Our Case Number: ABP-316119-23

Re: DART+ South West Electrified Heavy Railway Order - Hazelhatch & Celbridge Station to Heuston Station,
and Hesuton Station to Glasnevin
County Dublin and County Kildare

Observation: DART+ South West Electrified Railway Order 2023

Re.: Works Layout Plan No. 16, McKee Barracks Bridge (OB03) to Cabra Road Bridge (OB06)

Plan No. WORKS LAYOUT PLAN No. 16

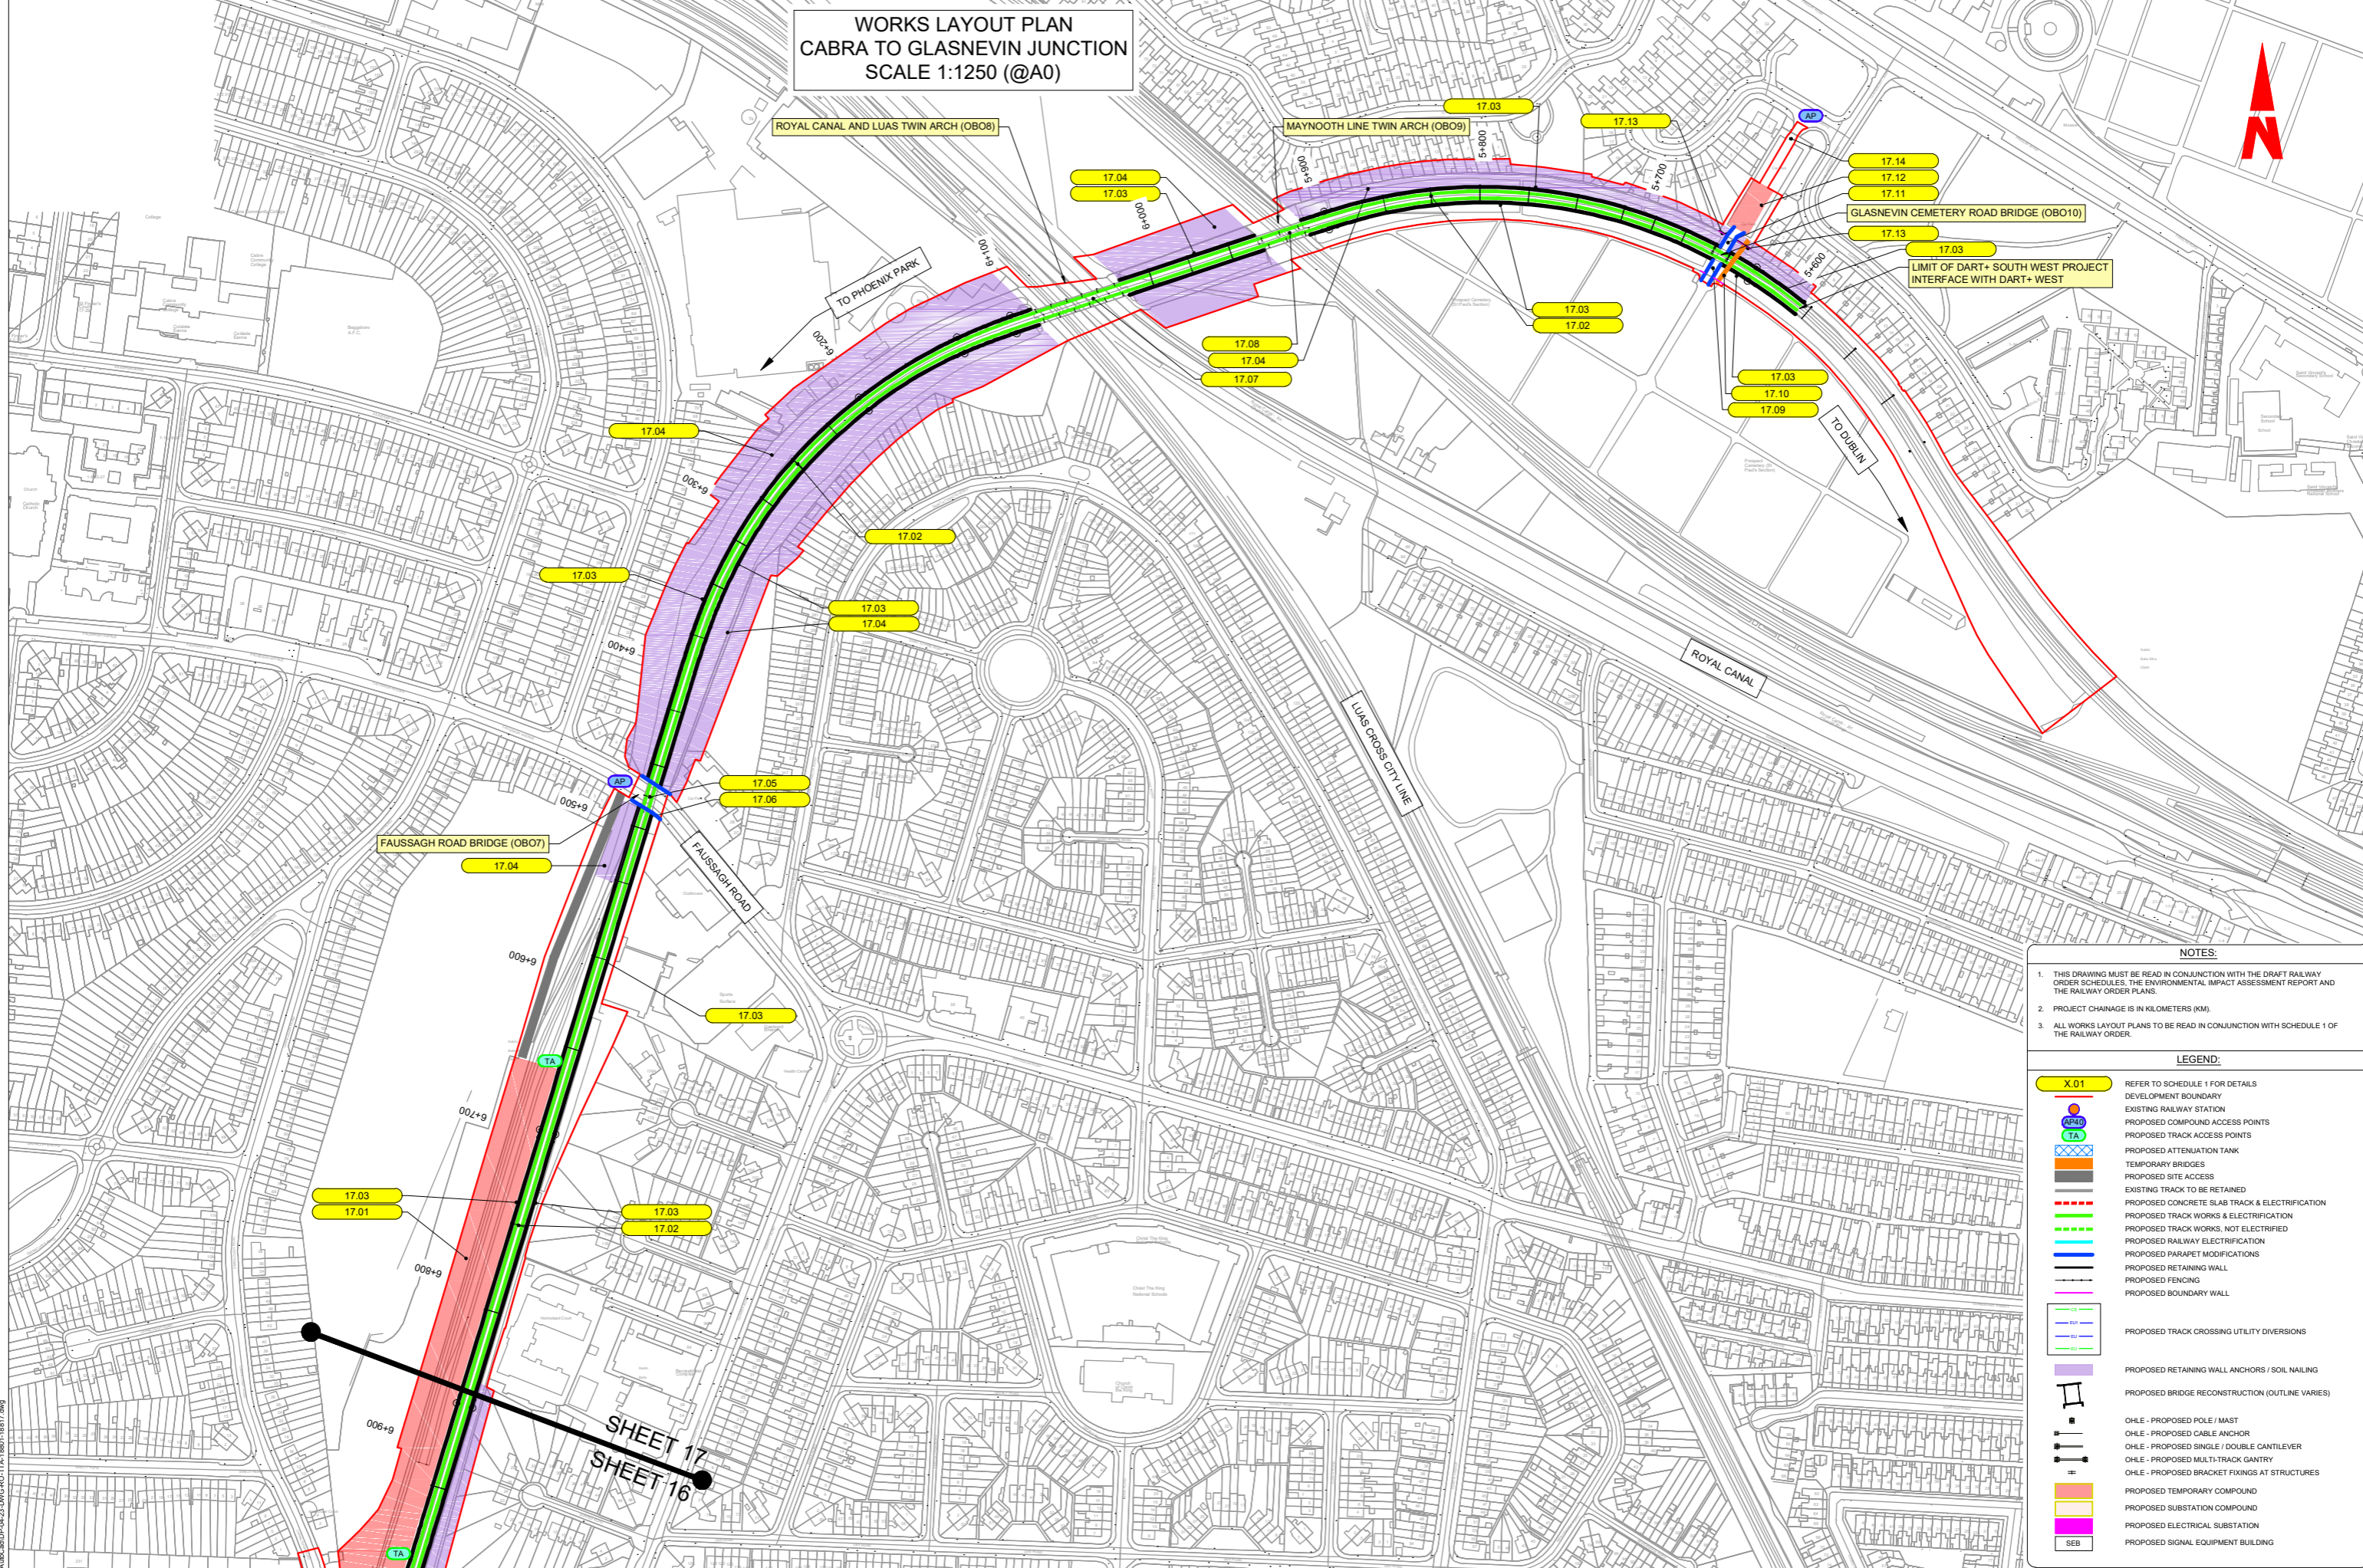
I am making my personal submission in addition to signing the group submission from my neighbours on Glenbeigh Road, pertaining specifically to Works No. 16.10 of the Railway Order:

"Construct a palisade fence on top of an existing low level masonry boundary wall. Works also include localised repairs to the existing boundary wall"

10. The railway line itself and the proposed site of the material works is significantly below the level of the adjacent land embankment and existing cut stone boundary wall in question (approx.. 50 ft below the high embankment). While it is recognised that, as part of the Railway Order, Iarnrod Eireann is seeking to make secure and protect the railway line by making boundary works, it will not achieve a greater level of protection than is already being provided by the existing natural mature tree lined verge boundary and boundary fencing already provided for by the residents over the years.

1. Alternatives to the location of the proposed building of the palisade fencing and repairs to the boundary wall, as marked in Plan No. 16.
2. Choice of boundary work materials to be permitted e.g., greening/planting of beech hedging, willow or trees or alternative less harsh boundary treatment on the external boundary with the railway line and embankment might be more appropriate and suitable in a biodiversity/climate crisis and that state bodies should be demonstrating good design and ecological / green infrastructure when undertaking any works in 2023.
